**ADC Planning Consultation
Response from the Historic Buildings Adviser**

Application Number	AL/45/13/L
Address	Letterbox Cottage, Norton Lane, Aldingbourne
Description	Application for listed building consent for the demolition of existing garage and erection of new detached garage building (resubmission following AL/109/12/L).
Case Officer	Simon Davis
Site Visit	Previous

PROJECT		
Proposed replacement garage at Letterbox Cottage, Norton Lane		
SUBJECT		
Proposed Plans and Elevations		
SCALE	DATE	DRAWING No
1:100	June 2013	
DRAWN	CHECKED	2012 / 30 / 05

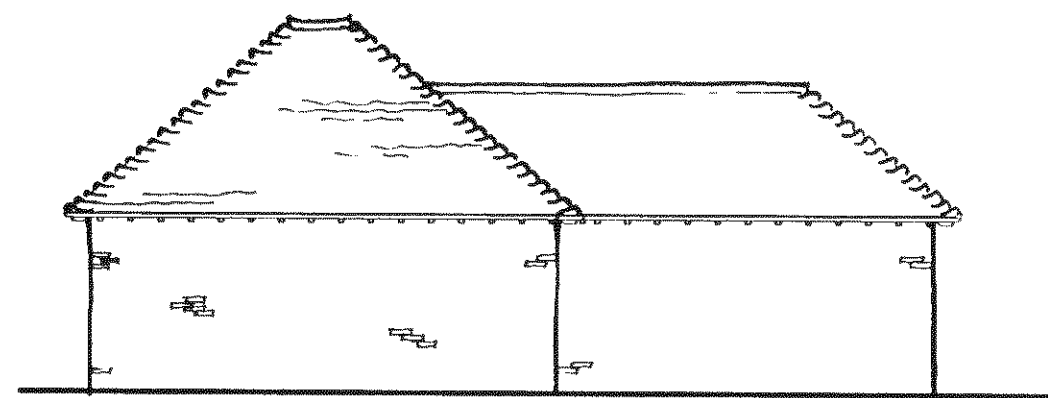
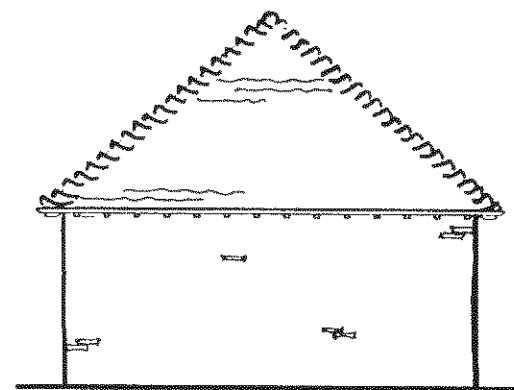
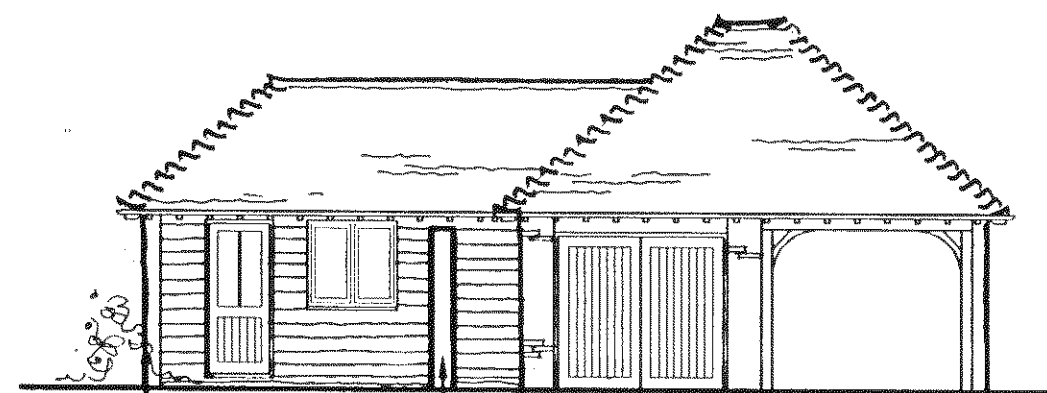
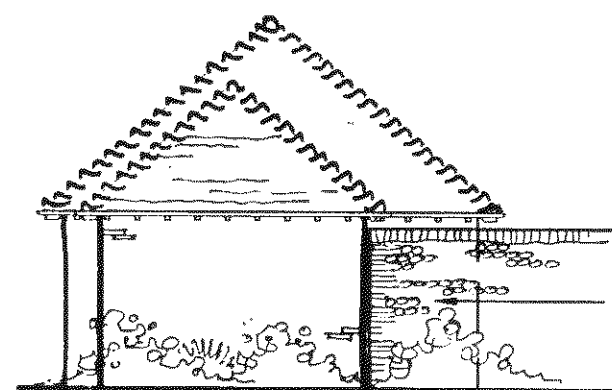
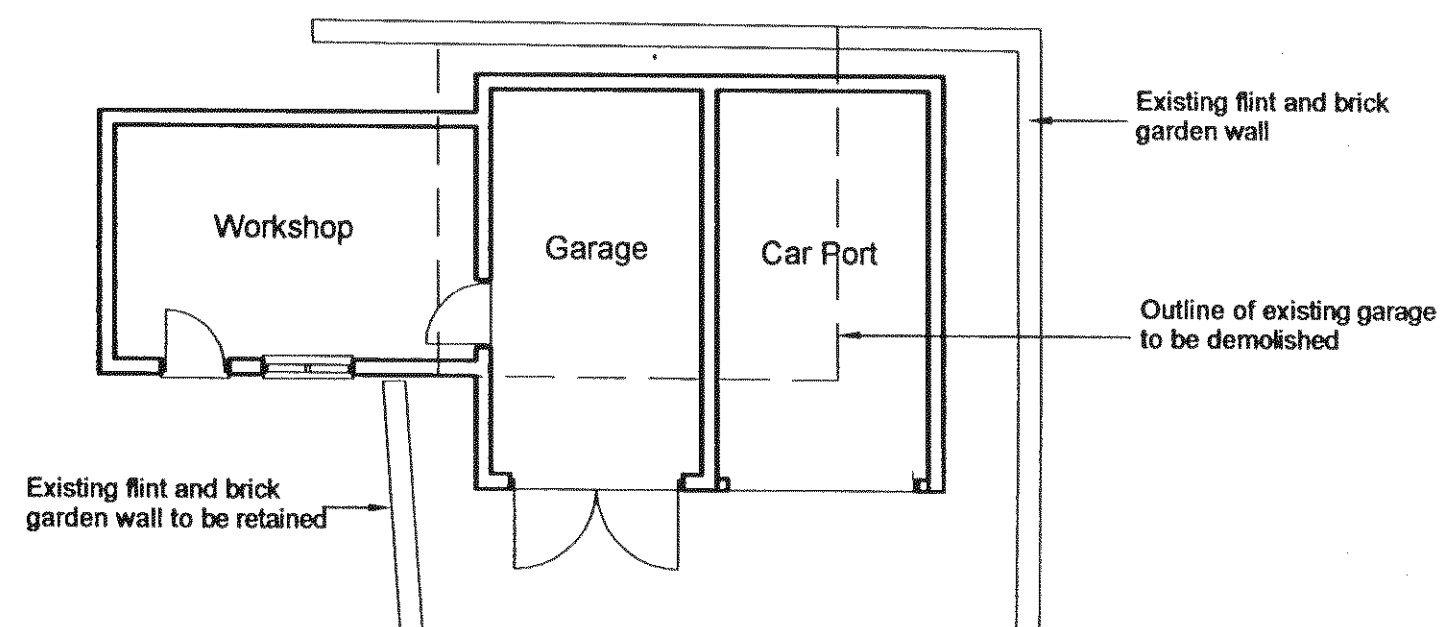
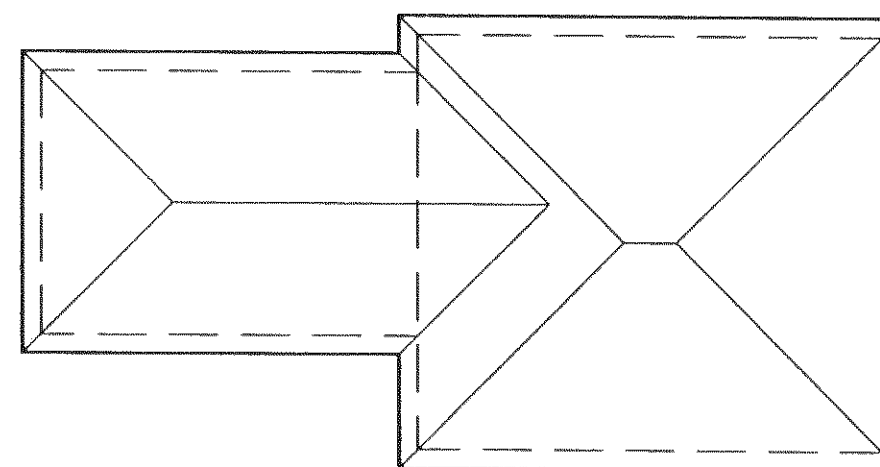
Whilst this scheme has largely sought to resolve a number of issues raised following refusal of AL/109/12/L, there remains a concern with the linking of the workshop with the garage which appears incongruous in this context. The main issue here is the manner in which the workshop appears to traverse the extended line of the masonry wall, particularly as a timber structure. This does not seem to read as a logical evolution of the built elements here and as such does not sit well in its context. Furthermore I am not convinced that the use of featheredge boarding works in an area that is predominantly characterized by masonry structures.

The painting of the doors and windows to 'match the house' would also be problematic, especially if featheredge boarding was to be used. Outbuildings are generally more sympathetic in dark tones.
